2 Chelsham Road
London

Re: Provision for Vehicle Crossover at 2

PROPOSED VIEW

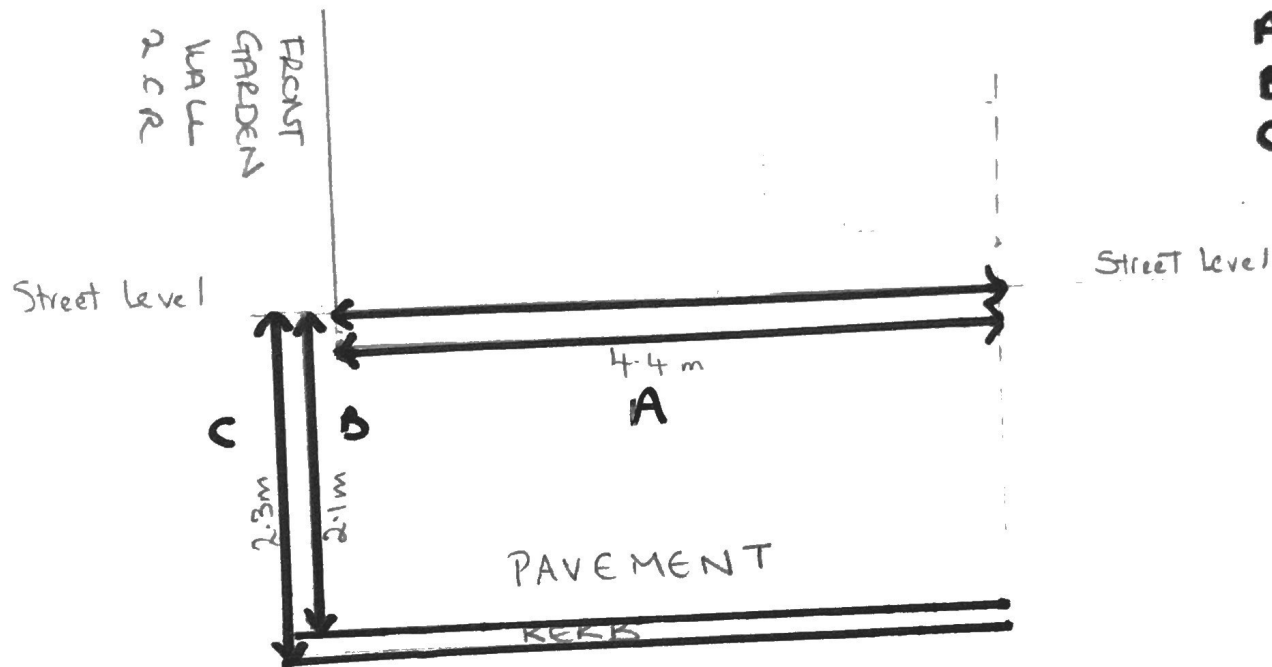
I confirm that the dimensions of your car parking space meet the Council's minimum criteria of 2.4m wide by 4.8m deep which is required to accommodate a vehicle without it encroaching onto the public highway.

Please note that the maximum width permitted for the crossover is 4mtrs. I confirm that the proposed location of the crossover would not adversely impact on highway safety. There are no immediate obstructions to visibility, such as trees, adjoining walls, etc, that would affect highway safety and visibility splays and pedestrian visibility splays that meet the Council's minimum requirements can be provided. Please also refer to the comments provided by the area engineer.

KW/ ITS IS CPZ AREA AND SEE BELOW. KW/ VISITED THE SITE AND MEASURED AND NOTED ENOUGH MEASUREMENT FOR PROPOSED CROSS OVER ON RIGHT SIDE OF THE PROPERTY. (5.3X3) HOWEVER NOTE THE FOLLOWING. THIS ALSO NEED TO REMOVE THE PRIVATE TREE IN PROPOSED CROSS OVER AREA THE PROPERTY .IN MULTIPLE OCCUPATION THEREFORE ITS NEED A FULL PLANNING PERMISSION . THEREFORE OWNER OF THE PROPERTY SHOULD APPLY TO OUR PLANNING DEPARTMENT FOR PLANNING PERMISSION..
